| <b>Address</b>                 | CARPENTER'S COTTAGE, FORMER RAF UXBRIDGE, ST ANDREWS PARK HILLINGDON ROAD UXBRIDGE                                                                                                                                                                                                                                                                                                              |                                 |
| <b>Development:</b>            | Demolition and replacement of roof structure (1.0 m higher eaves and ridge level), refurbishment and restoration of building including replacement windows and doors, to aid conversion of building to a single family dwelling house (Listed Building Application)                                                                                                                             |                                 |
| <b>LBH Ref Nos:</b>            | <b>585/APP/2020/2891</b>

EXISTING
STREET SCENE - SECTION A-A
SCALE 1:100

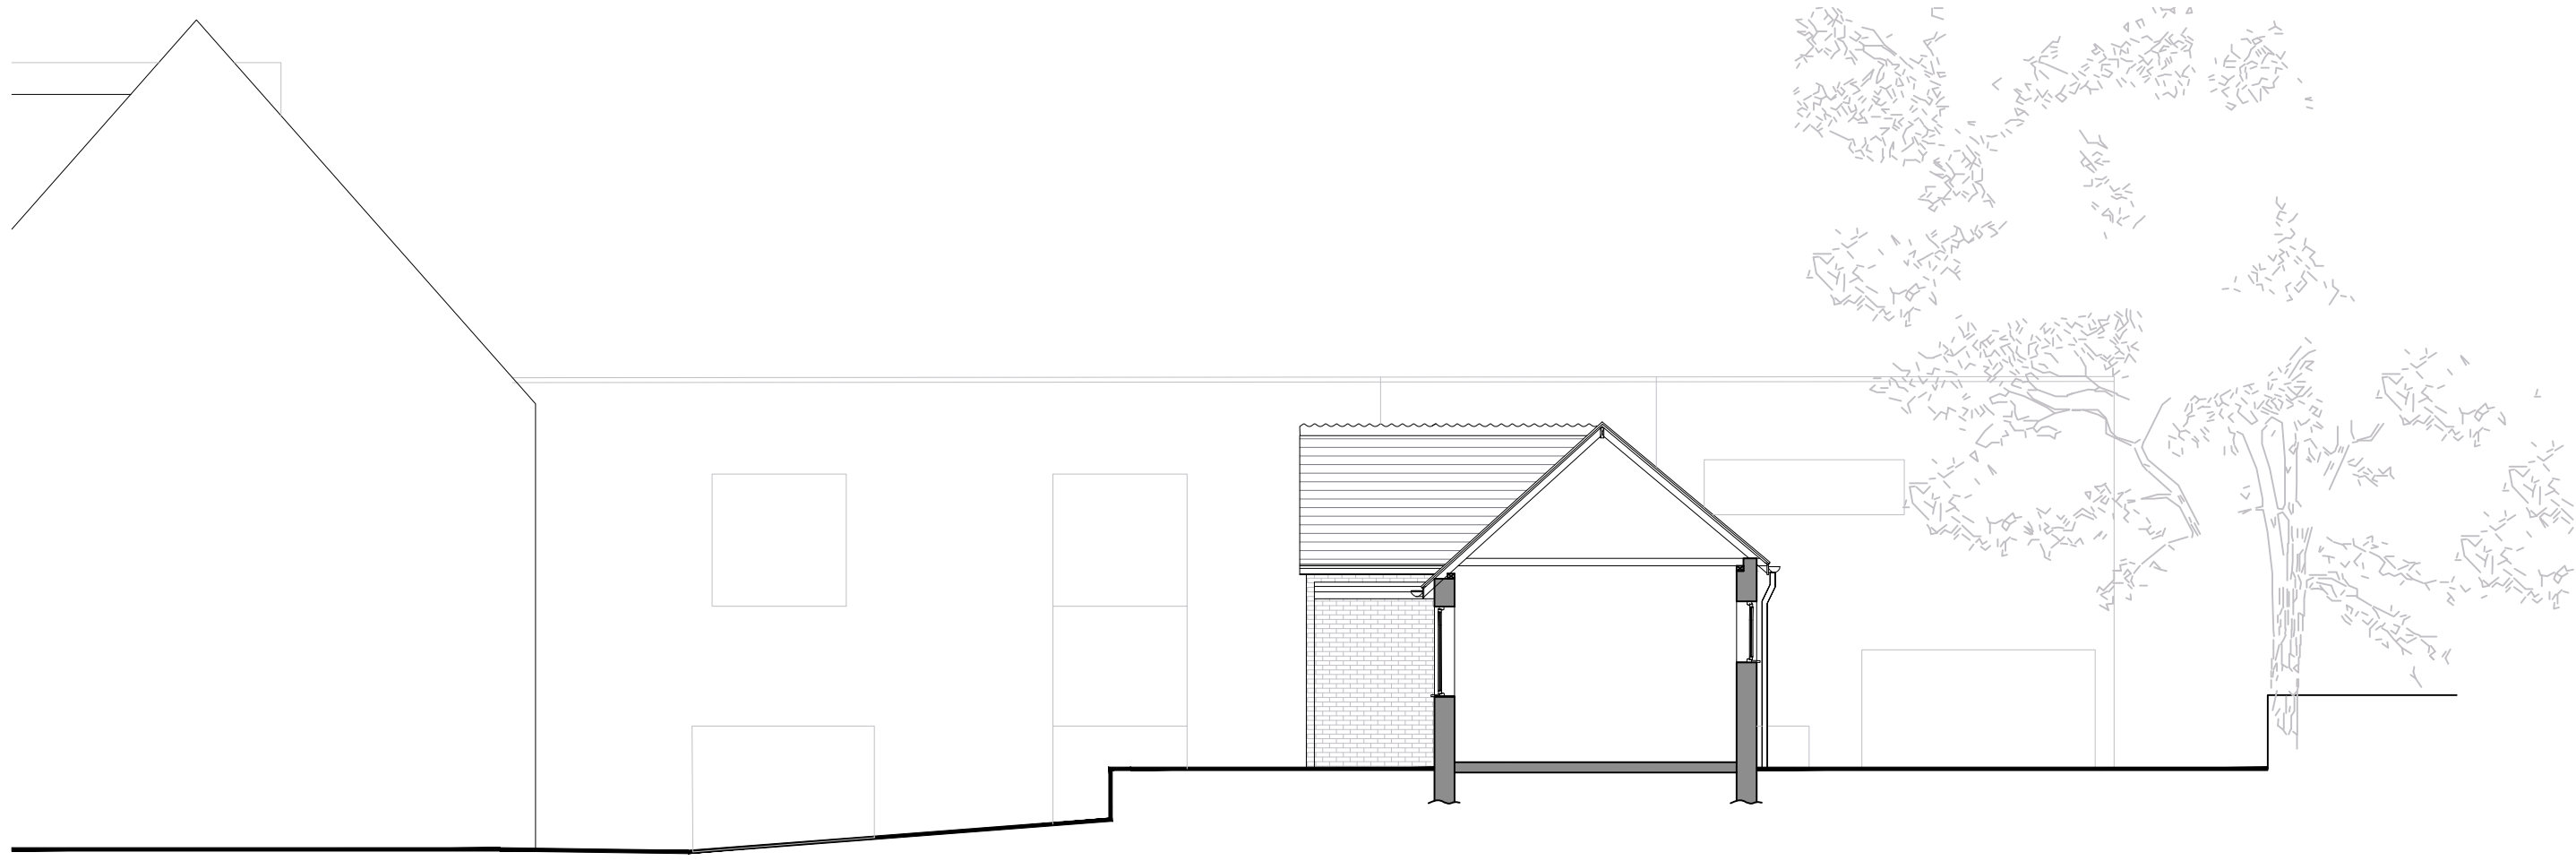
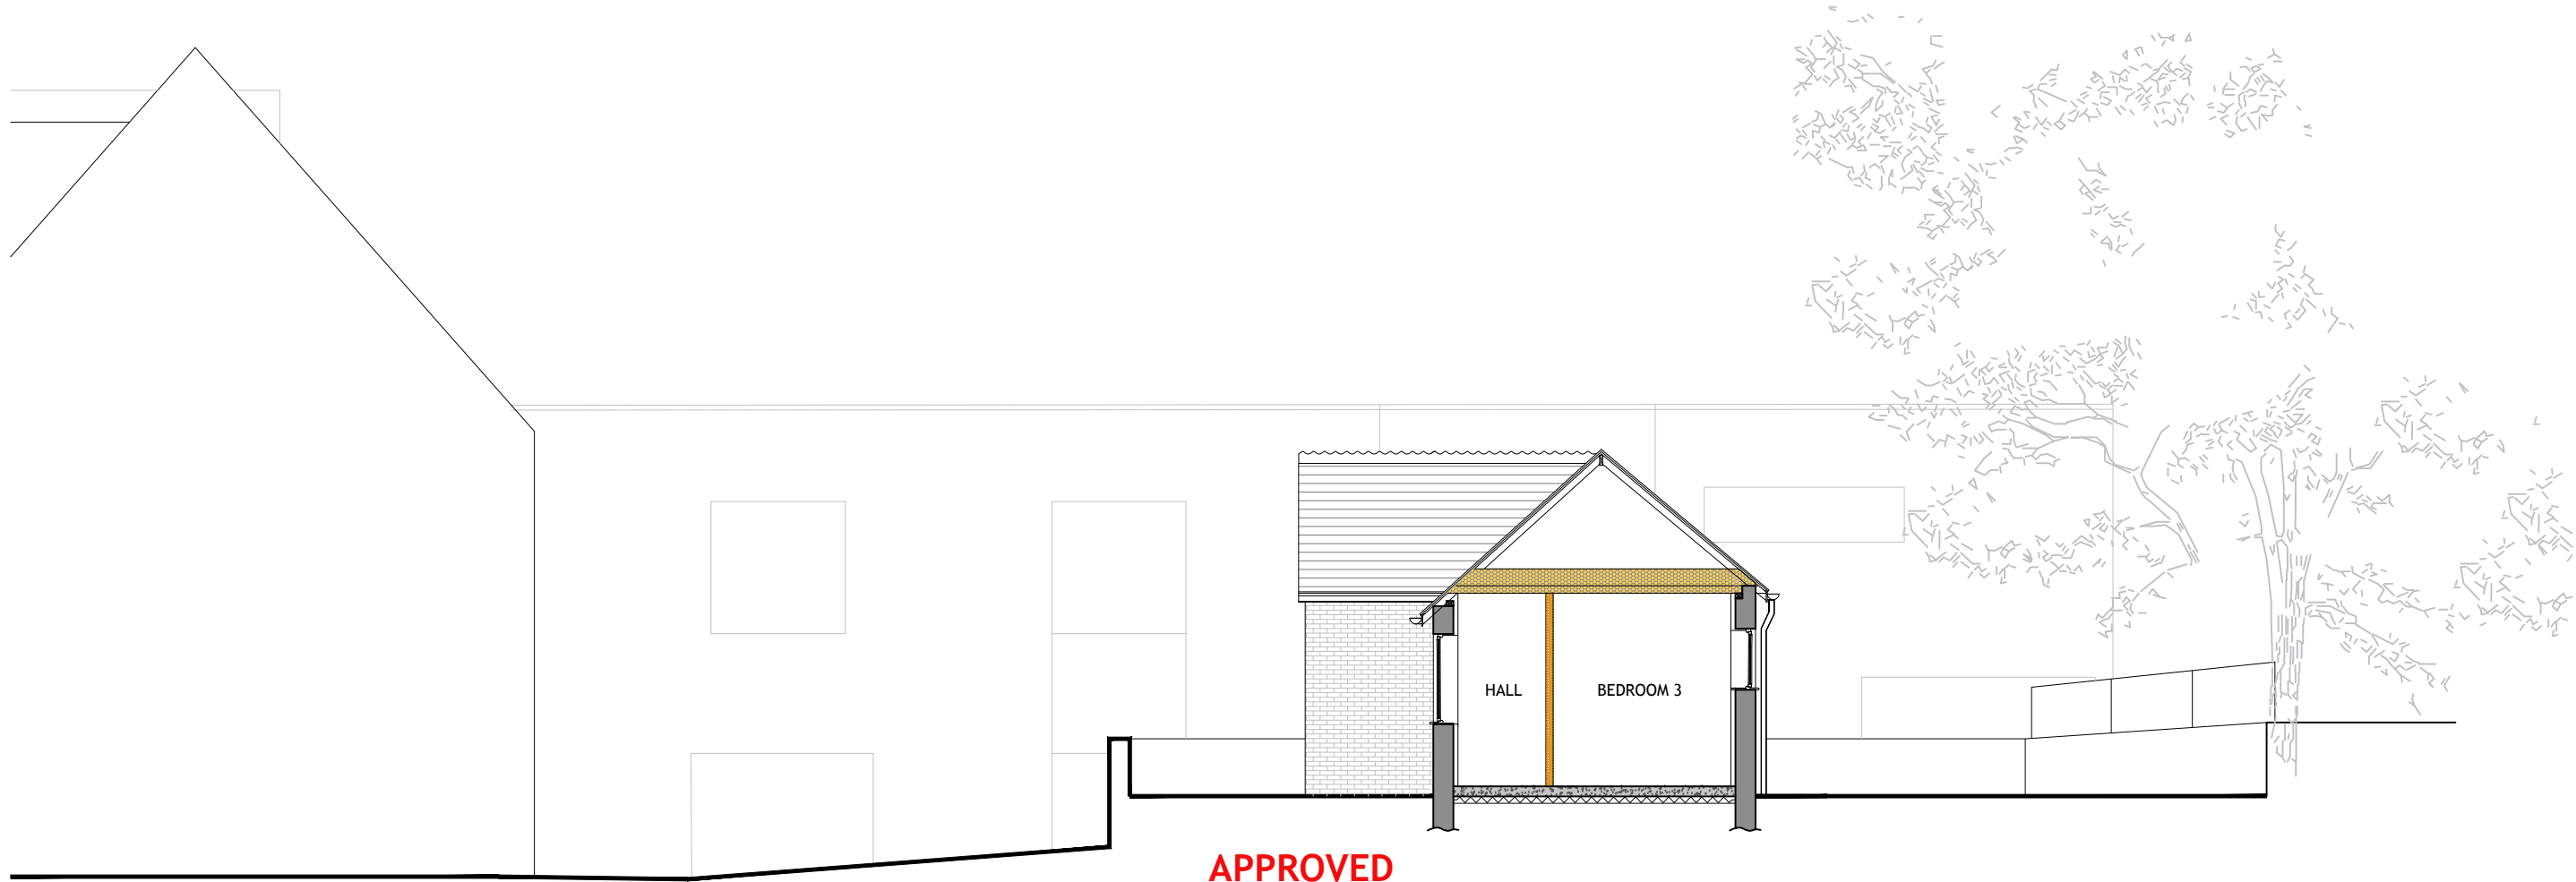
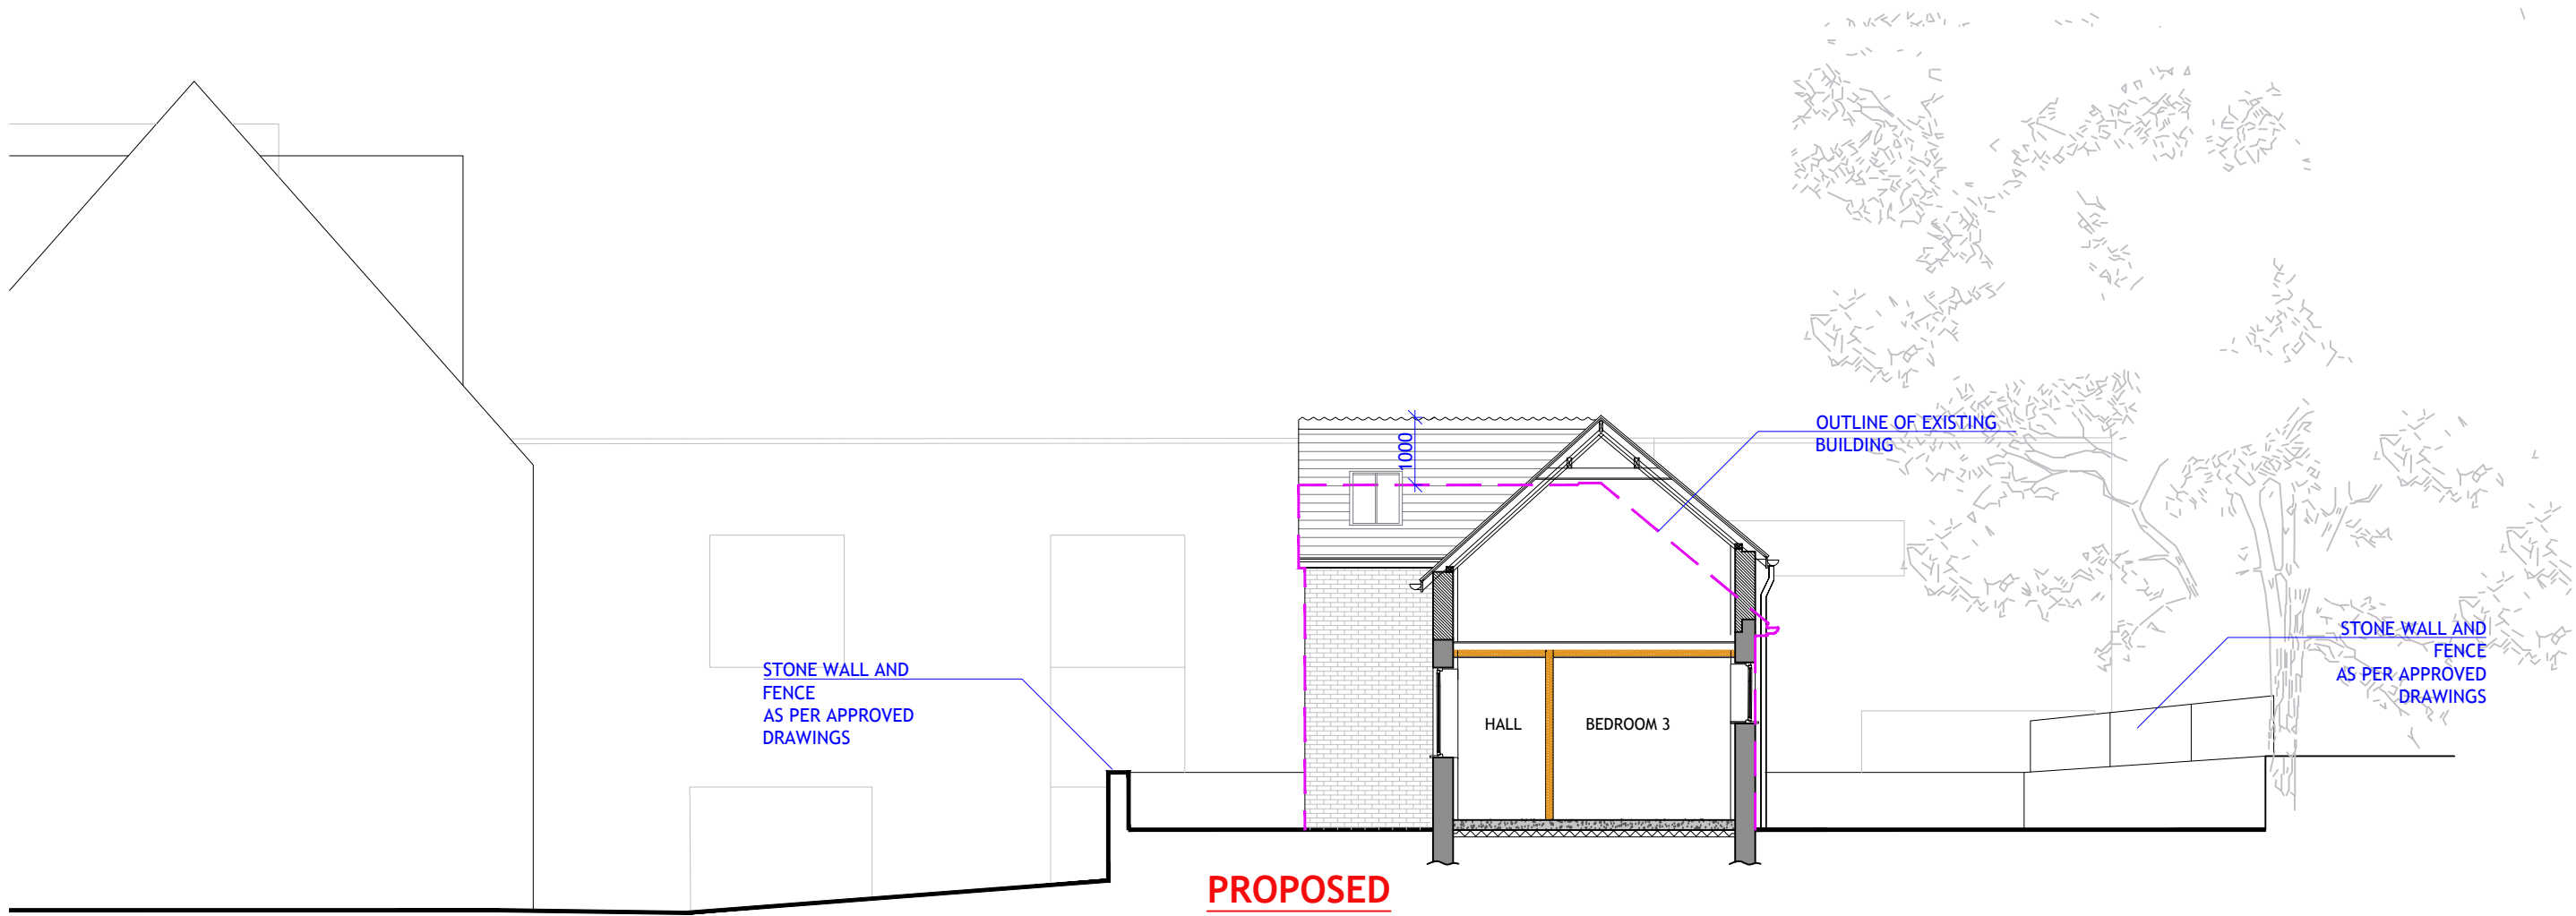
There are also concerns in terms of the thermal efficiency of the new roof structure. The submitted proposed section (Dwg No. 202039.P.302) does not depict any form of insulation within the new roof structure.

There are also concerns in terms of the thermal efficiency of the new roof structure. The submitted proposed section (Dwg No. 202039.P.302) does not suggest any form of insulation within the new roof structure, therefore the plans as submitted may not be an accurate representation of the work required/proposed to facilitate habitable rooms within the proposed loft.
